Submissions Report

Wallgrove Business Hub

SSD 50972718

May 2025

1 SECTION AA - STAGE 1 NORTHERN RETAINING WALL SCALE 1:50

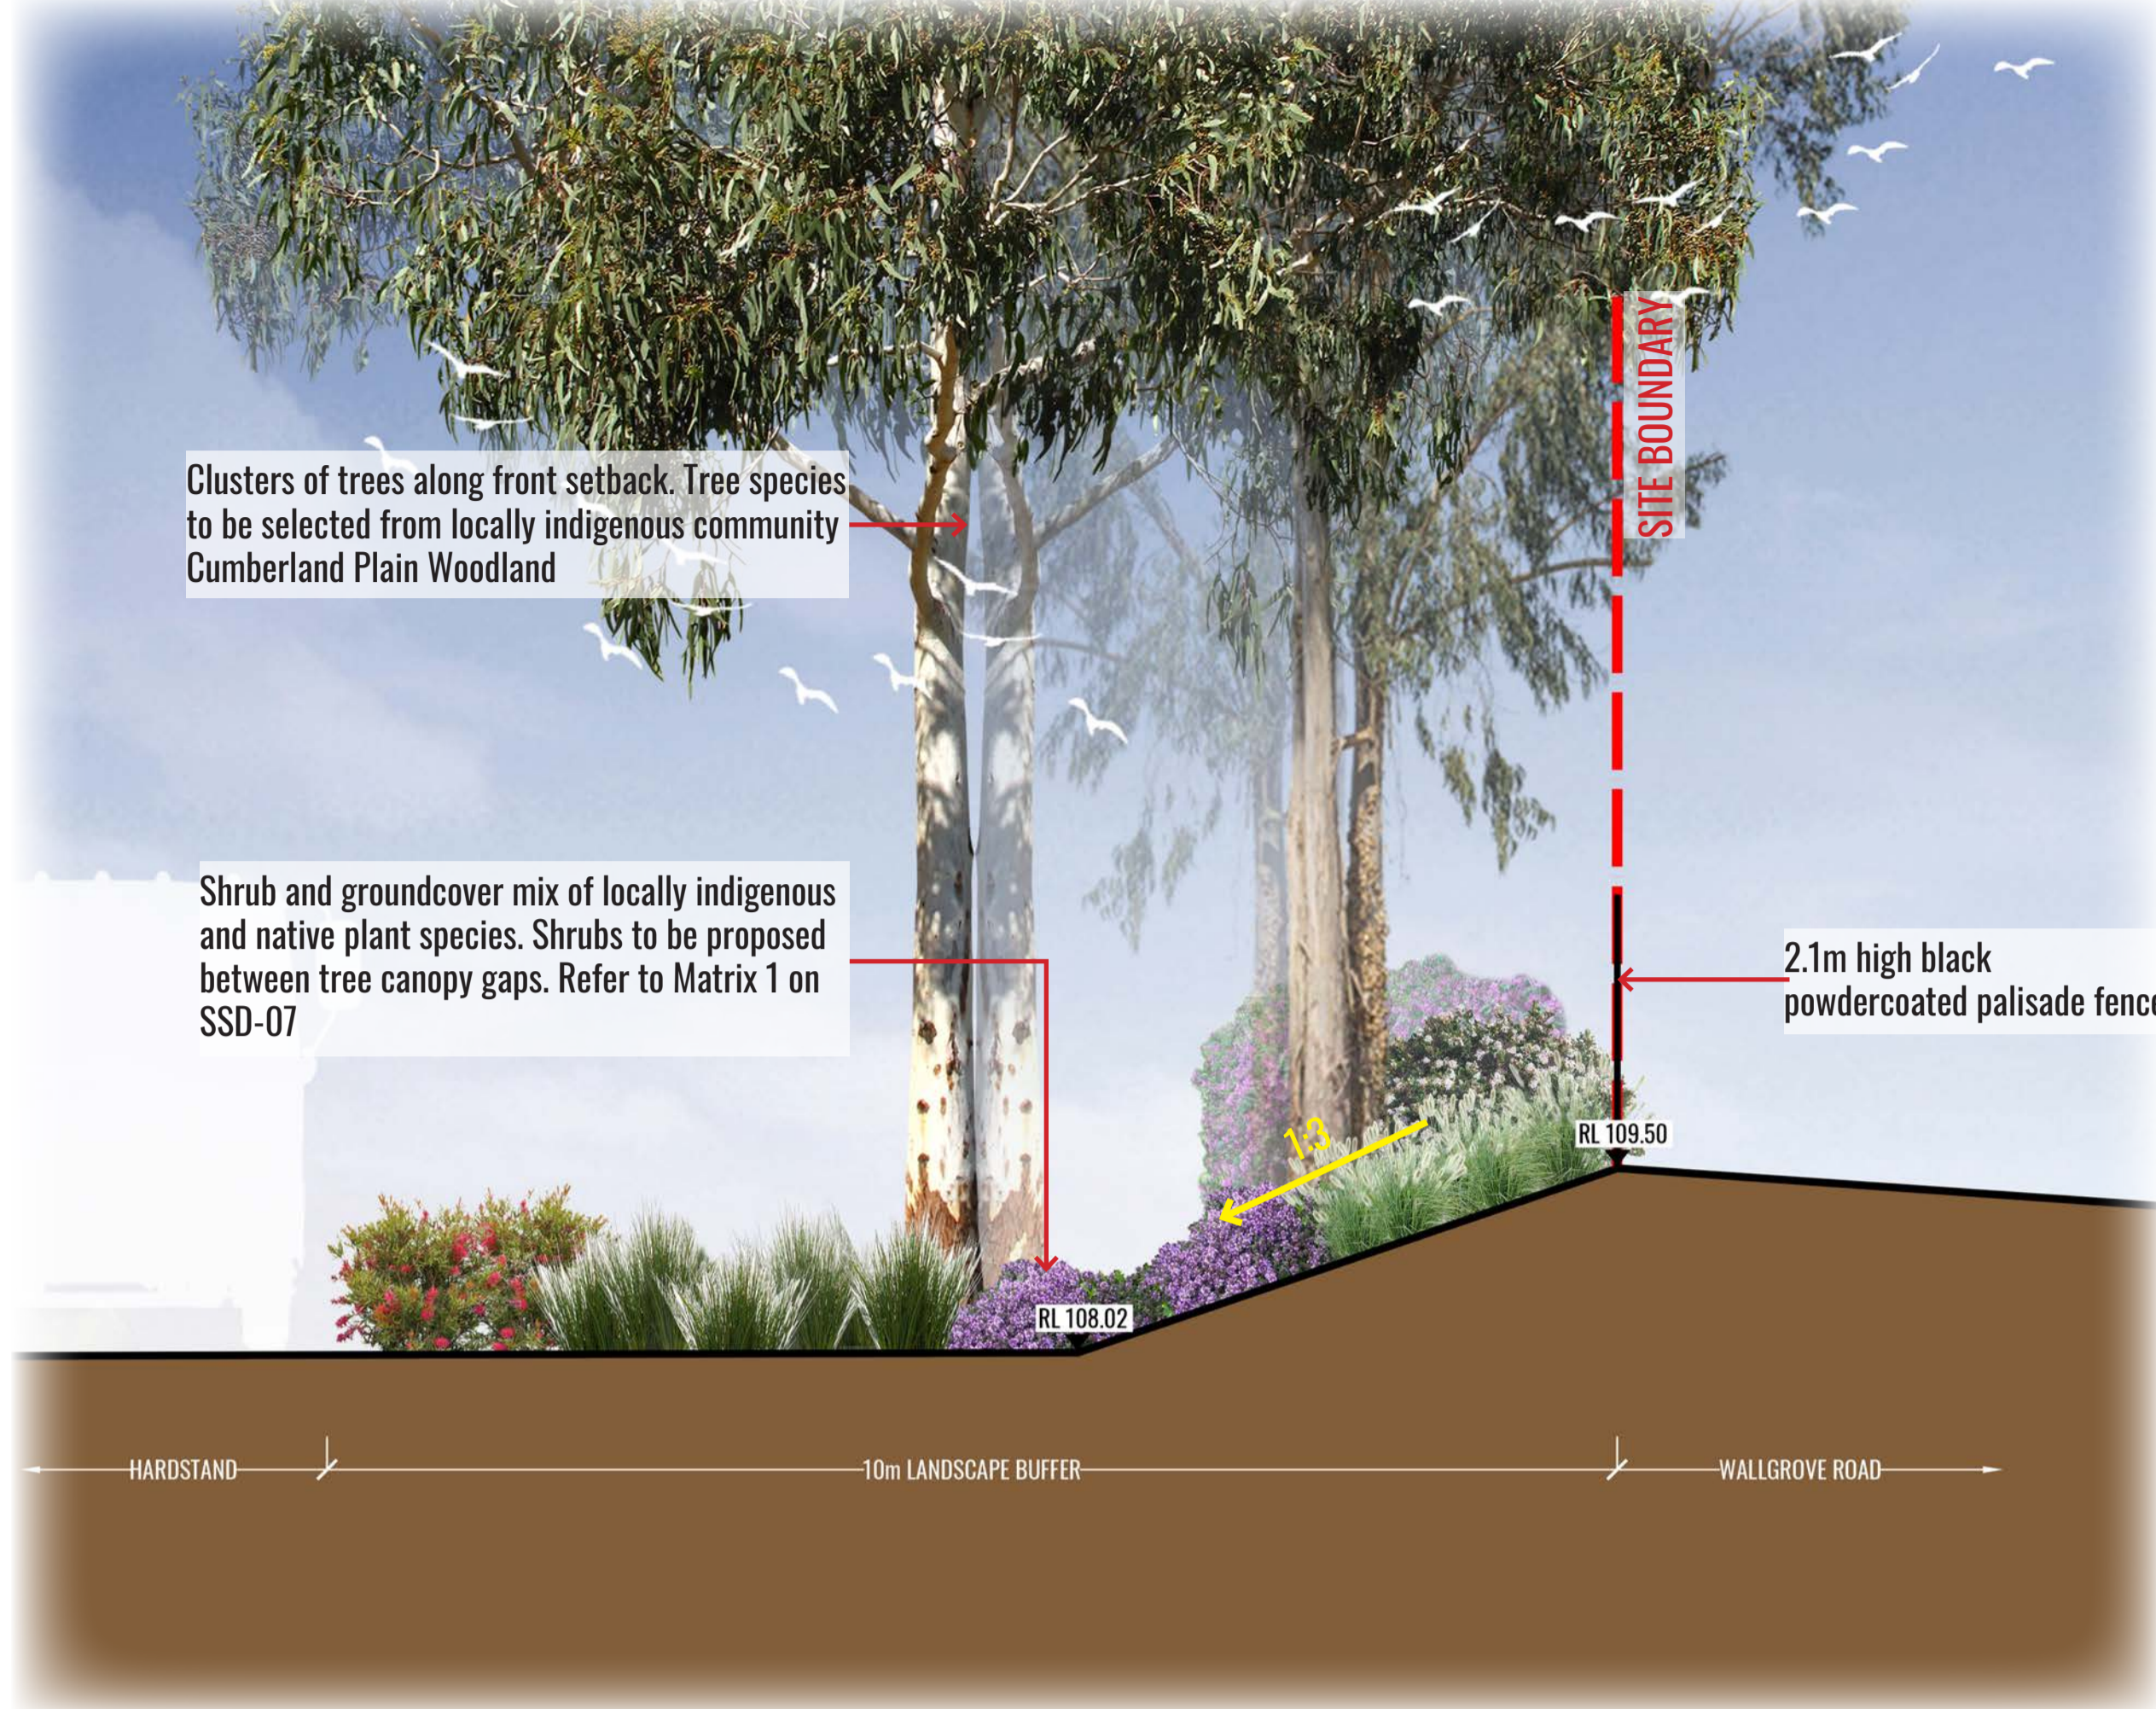
Ref.	Summary of submission	Submitter	Response
A	Retaining walls		
A1	Significant portions of the proposed acoustic walls will be on top of the retaining walls that are proposed as part of future development applications. Please detail how this will occur, revising any sequencing of the development as necessary.	DPHI	• A revised concept masterplan has been prepared by Nettleton Tribe (Appendix 2) • The plans incorporate revised acoustic wall height of 1.8m with retaining to the immediate north of warehouse 1, which is a significant reduction from the previous proposal (4.5m acoustic wall with retaining). • A 4.5m acoustic wall with retaining will remain to the north of the estate road / warehouse 2.
A2	Provide details on the height (i.e. RL levels) of the retaining walls proposed in Stage 1 works.	DPHI	• A preliminary grading and retaining plan has been prepared for a typical lot layout for the individual lots and is provided at Appendix 3. • The locations and heights of these retaining walls provided at Appendix 3.
